# CITY OF ALBUQUERQUE

April 18, 2022

**Re: Pima Medical Institute New Class Room Building**  
**4400 Culter Ave NE**  
**Traffic Circulation Layout**  
Architect's Stamp NO date provided (H17-D054B)

TITLE
Traffic Circulation Layout - Enlarged Plan

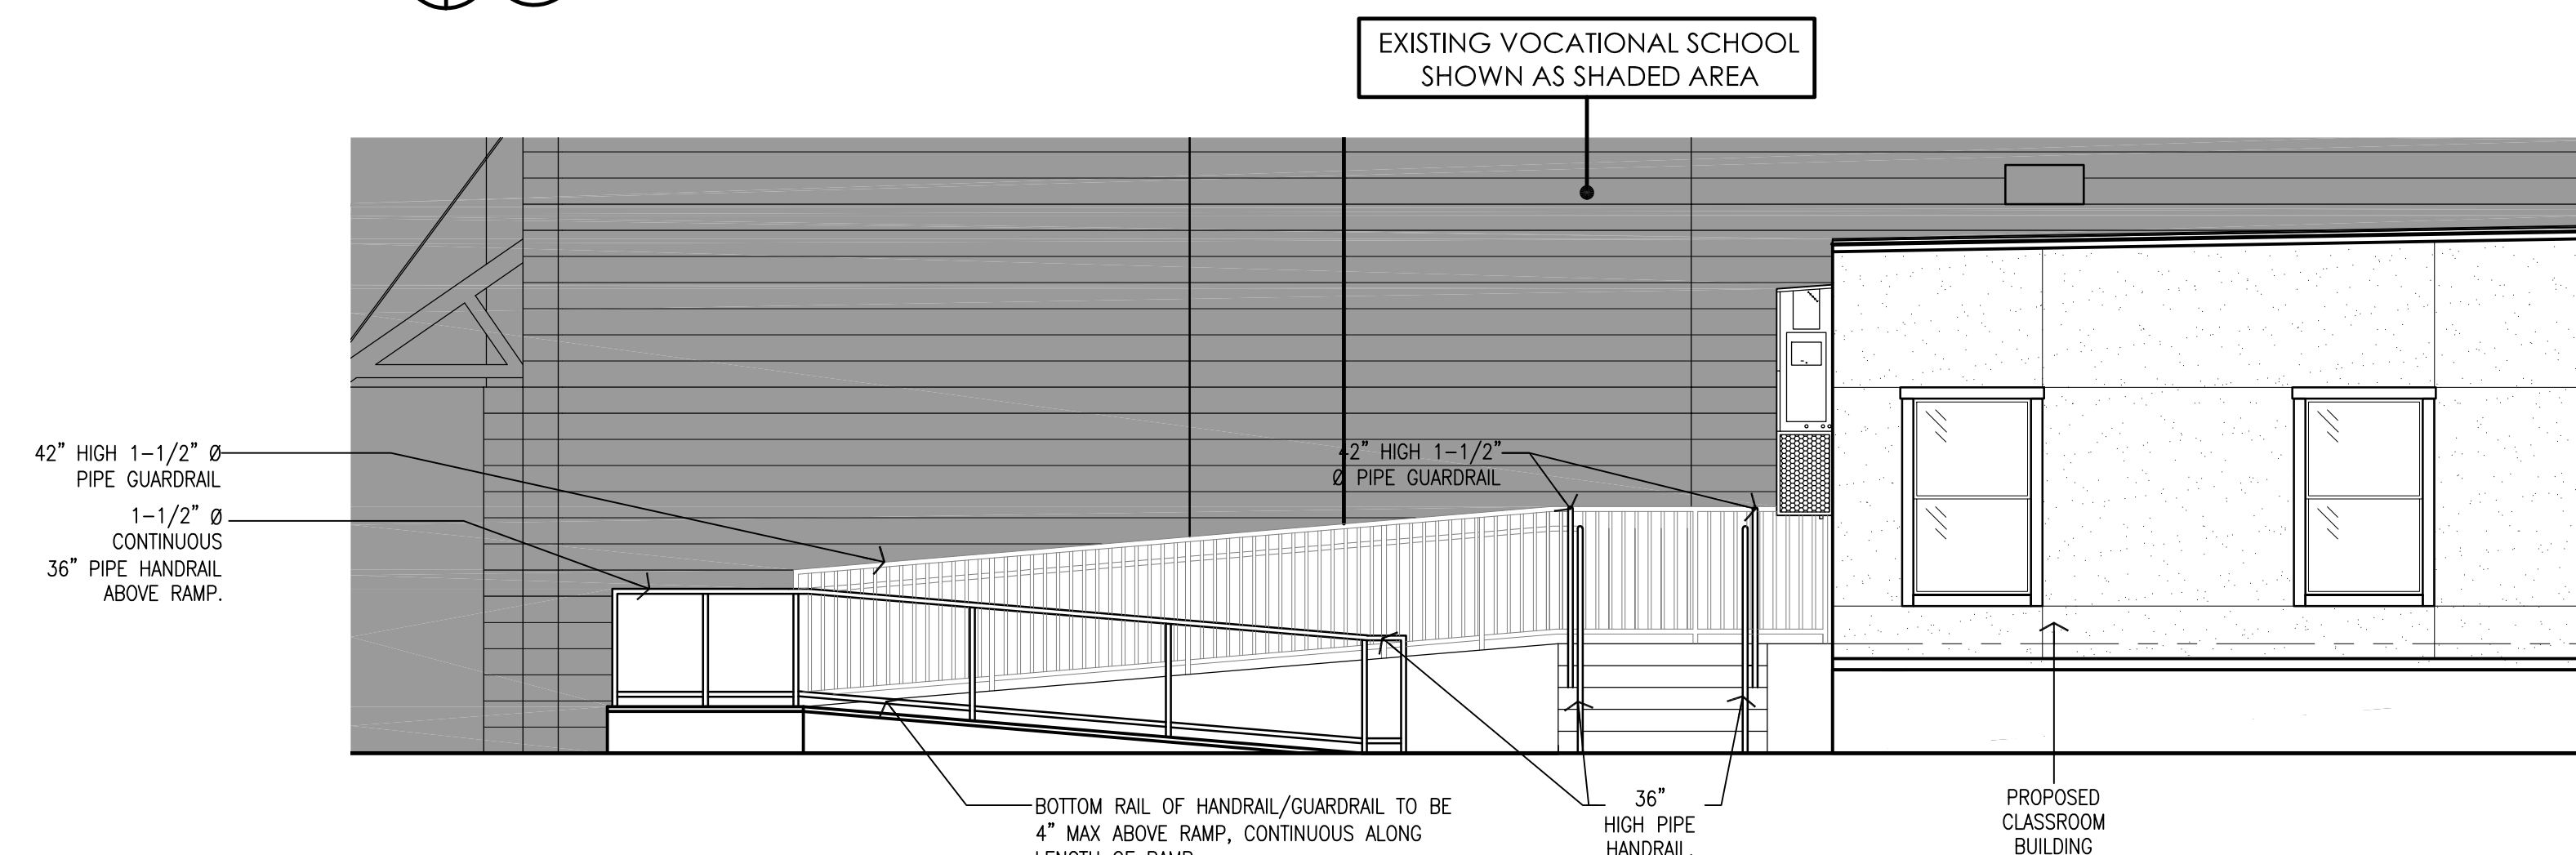
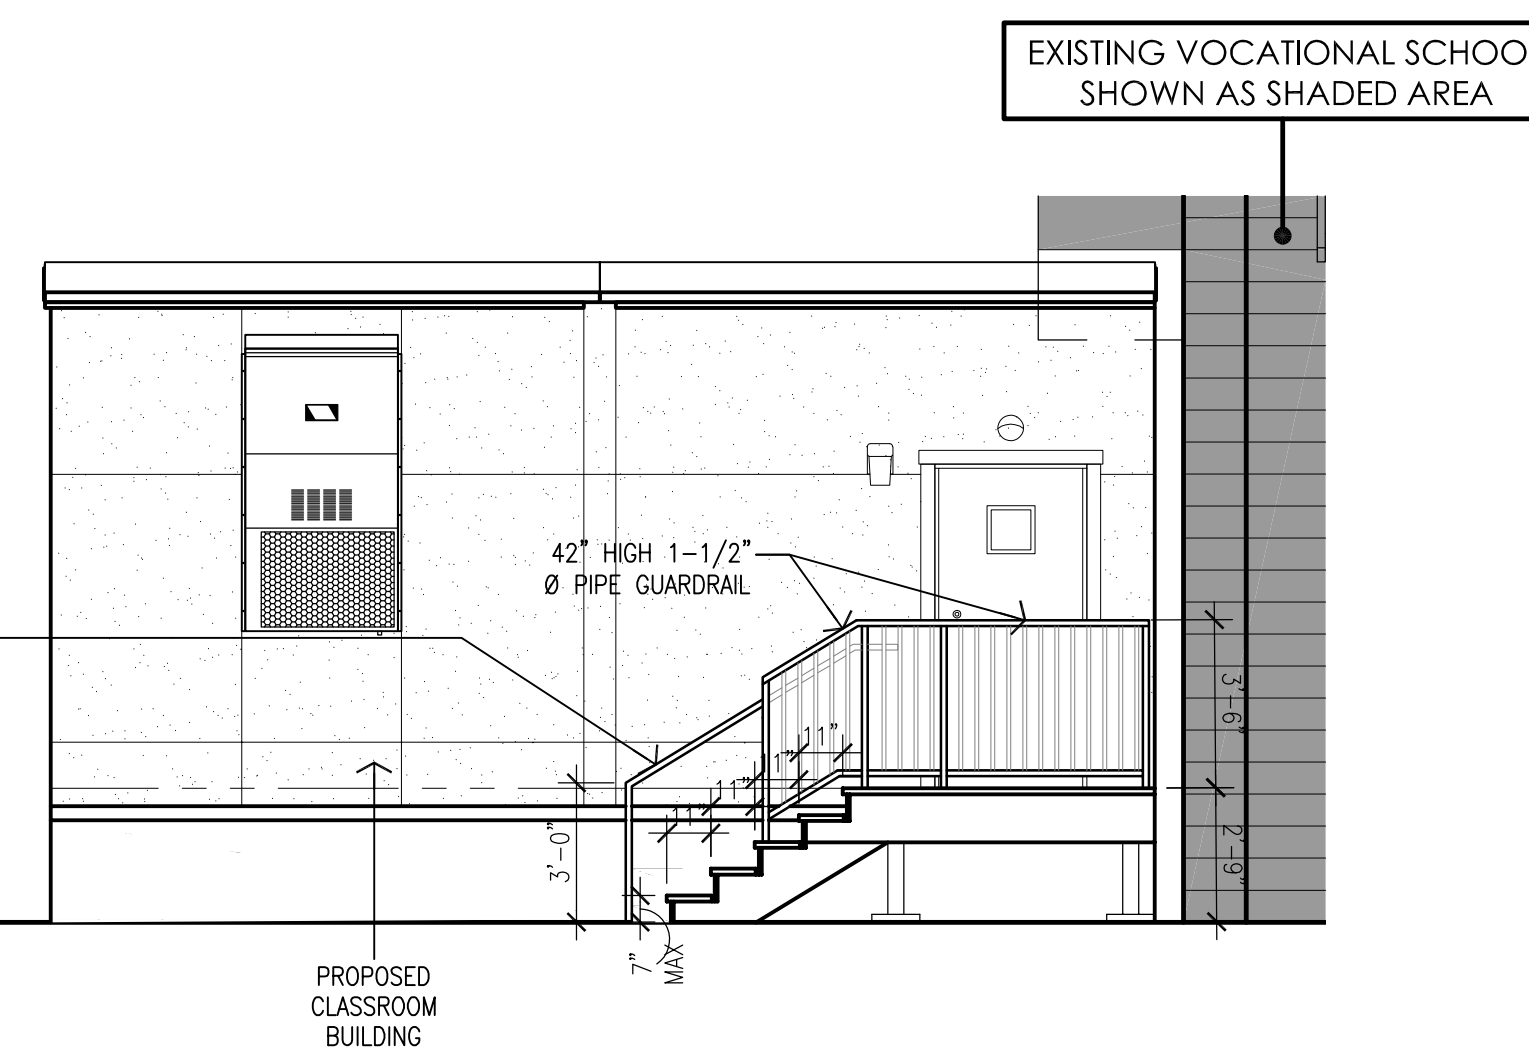
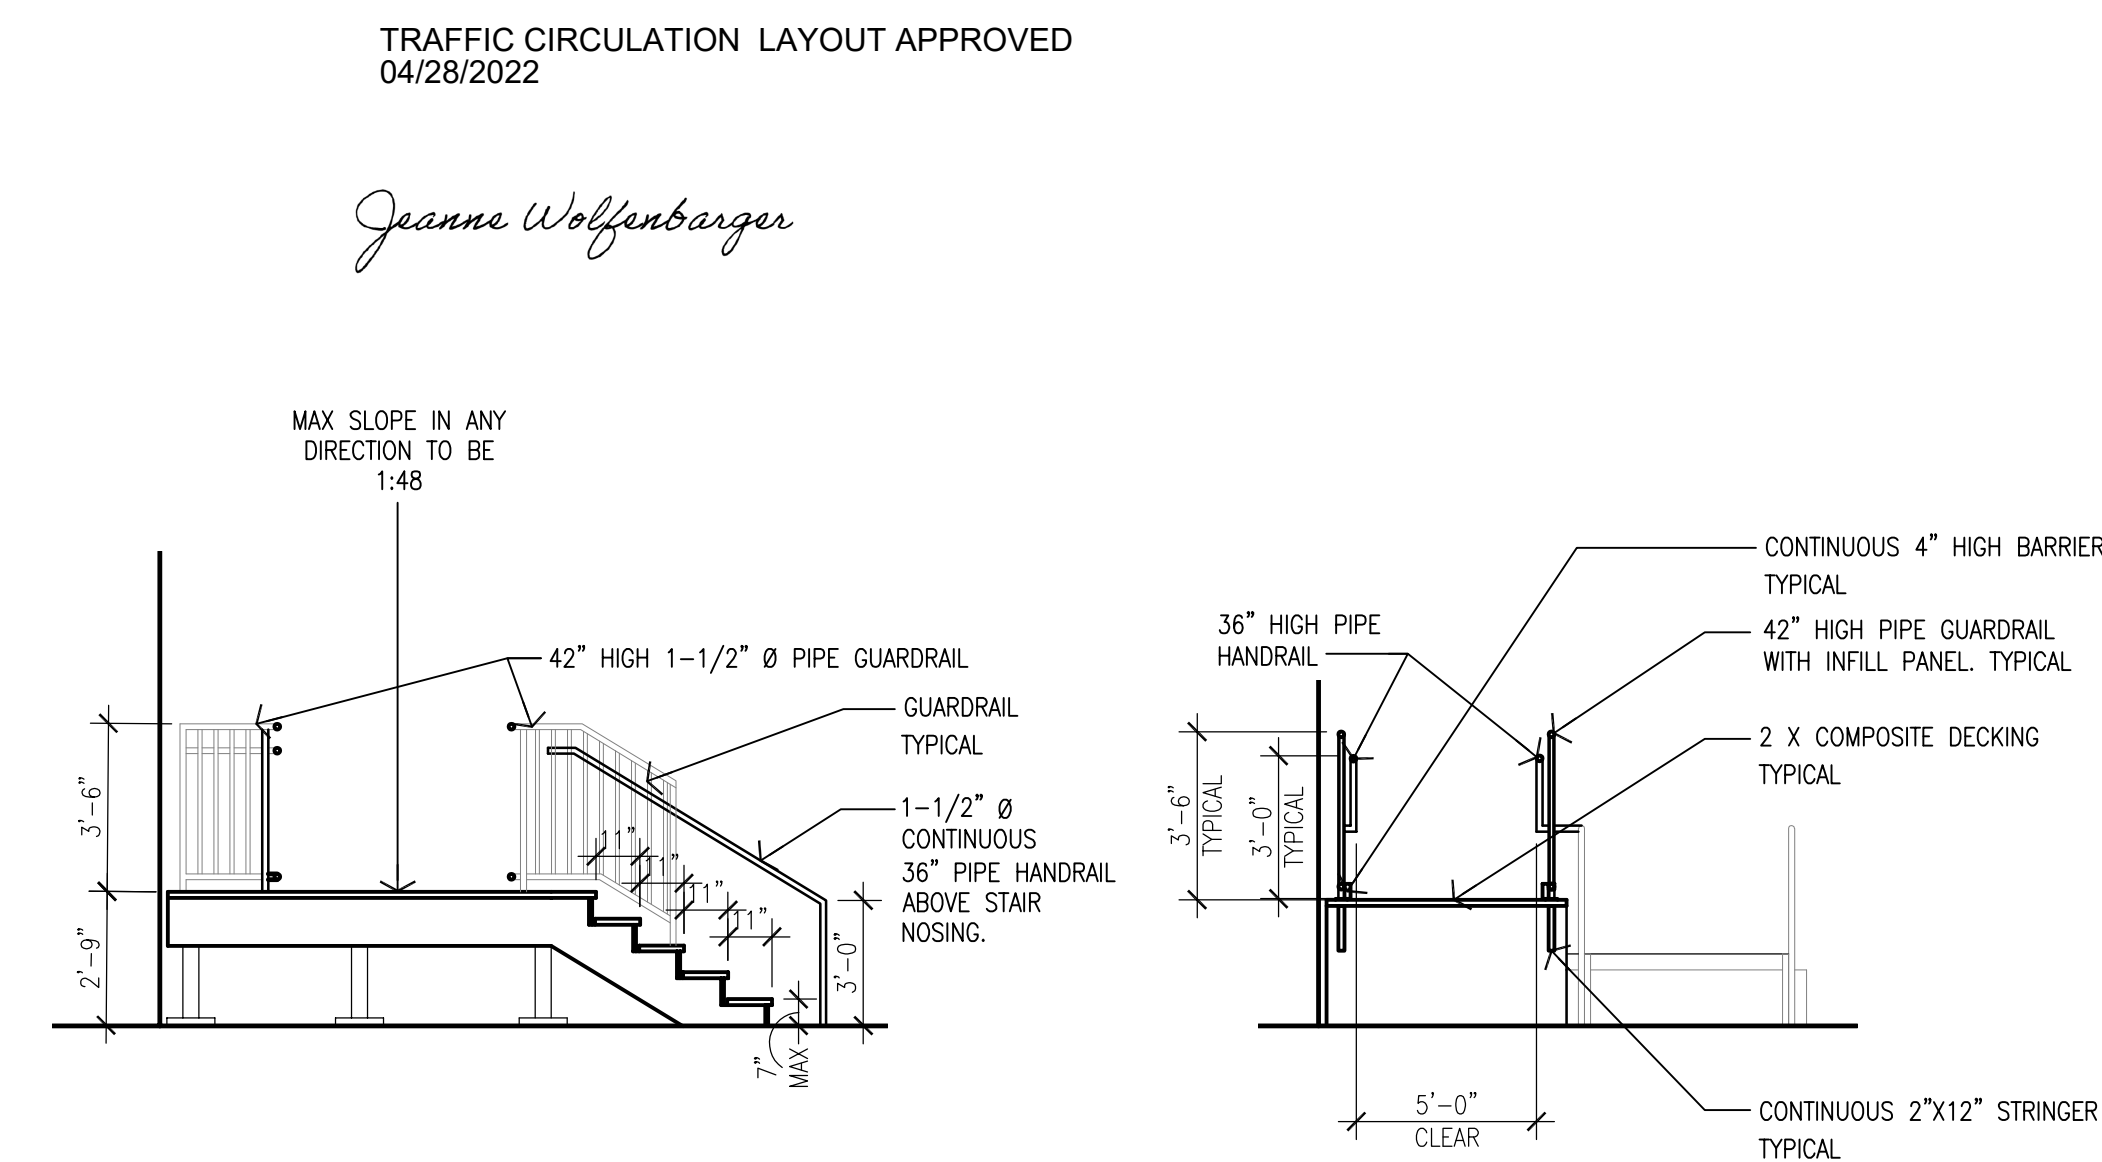
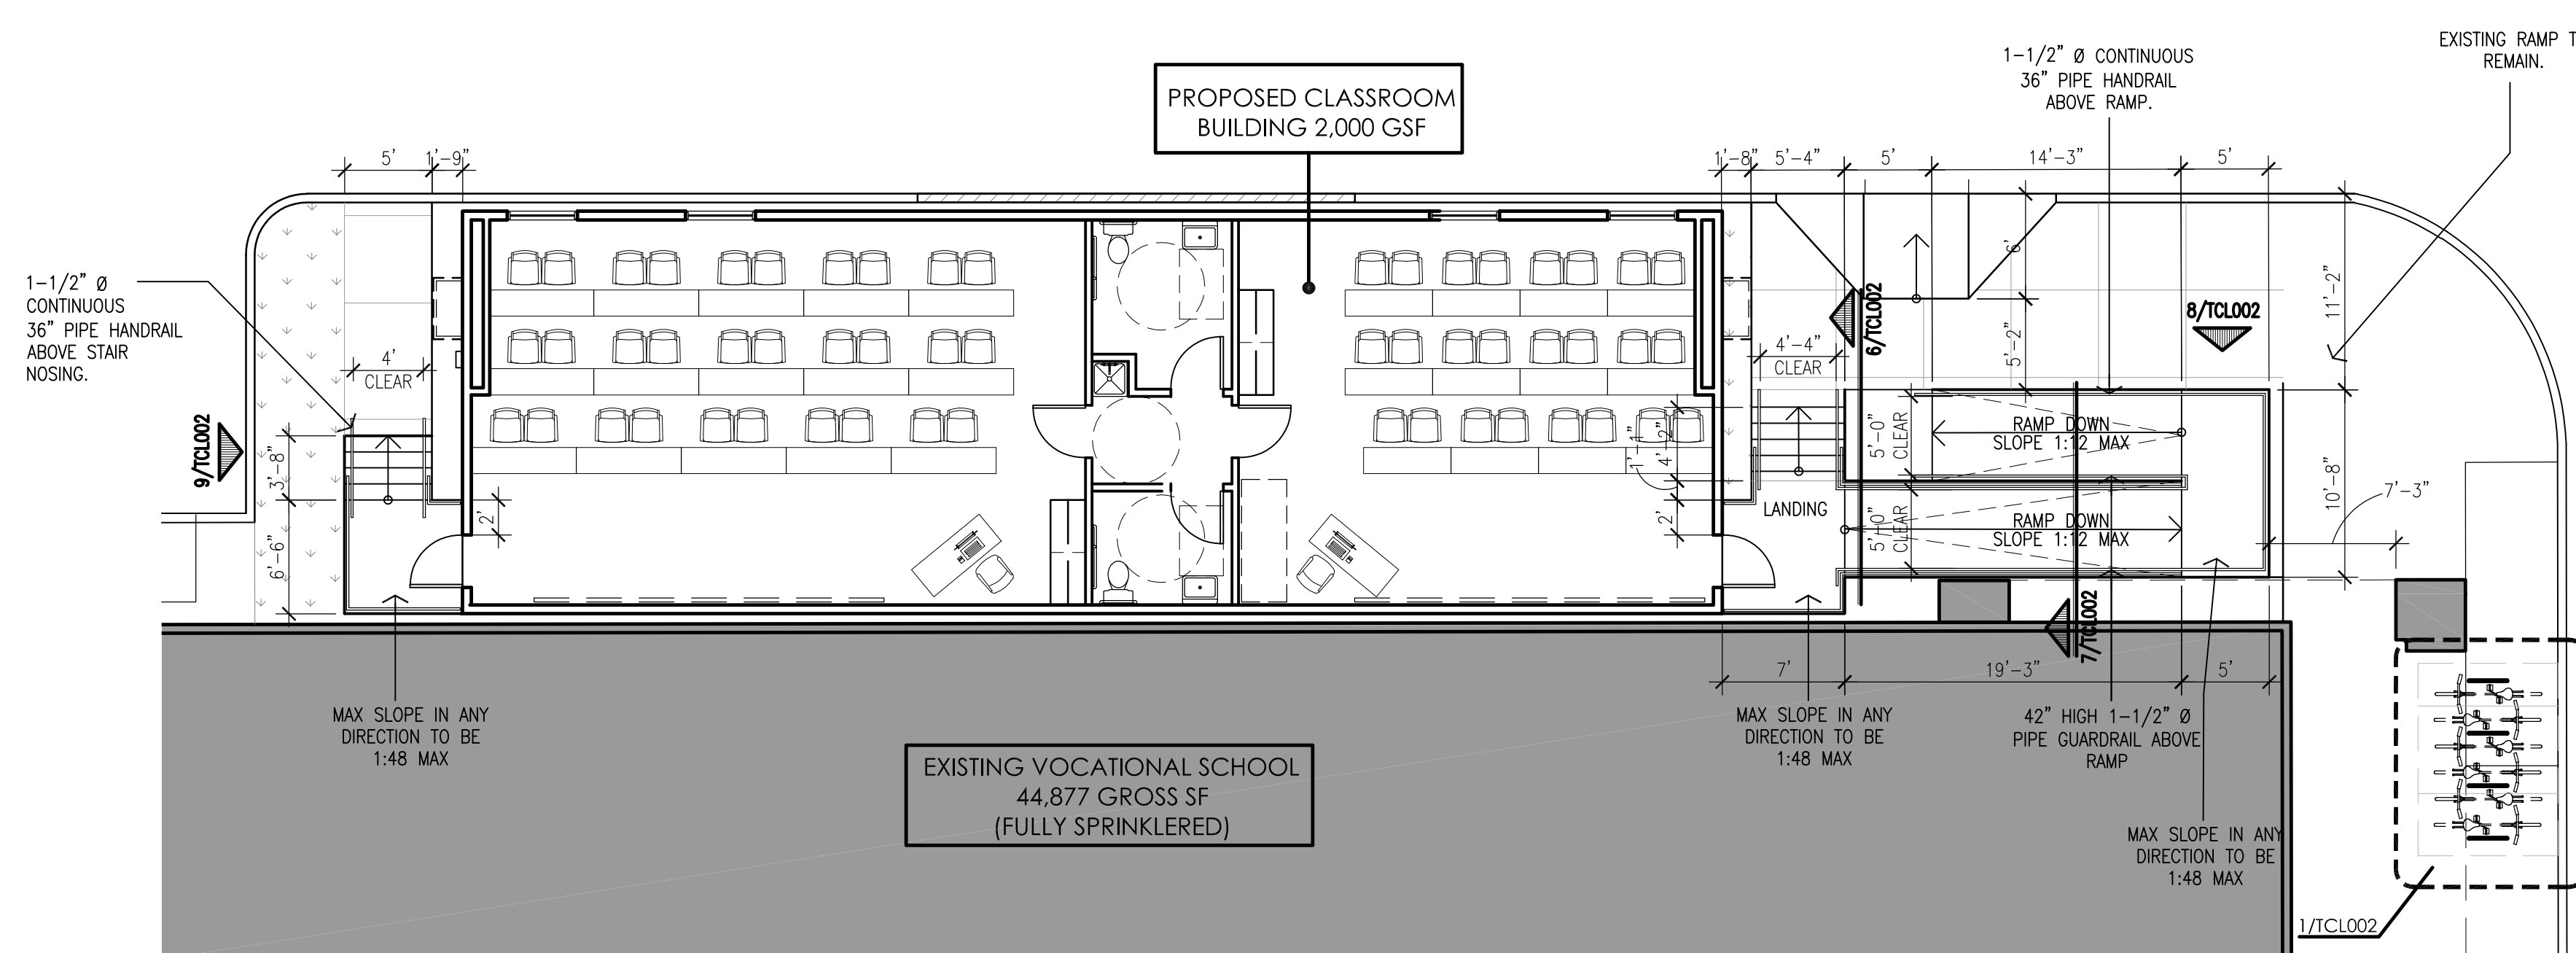
- The current ramp run (12:10) connection onto the sidewalk connection is not ADA accessible.
  - Per the DPM, a 6 ft. wide ADA accessible pedestrian pathway is required from the public sidewalk to the building entrances. Please clearly show this pathway and provide details and demo any existing/old sidewalk connection that doesn't meet the requirements above. Make sure you provide striping for this 6ft pathway across the drive aisle.

- **You will need a Sidewalk Easement for existing sidewalk located outside of public ROW. See attachment for the forms.**
3. **Handrail detail:**
  - Dimension all pathway widths on the proposed run/tapers and landings (including bottom, middle and top). Label all landings 48:1 **MAX** and all runs/tapers 12:1 **MAX**.
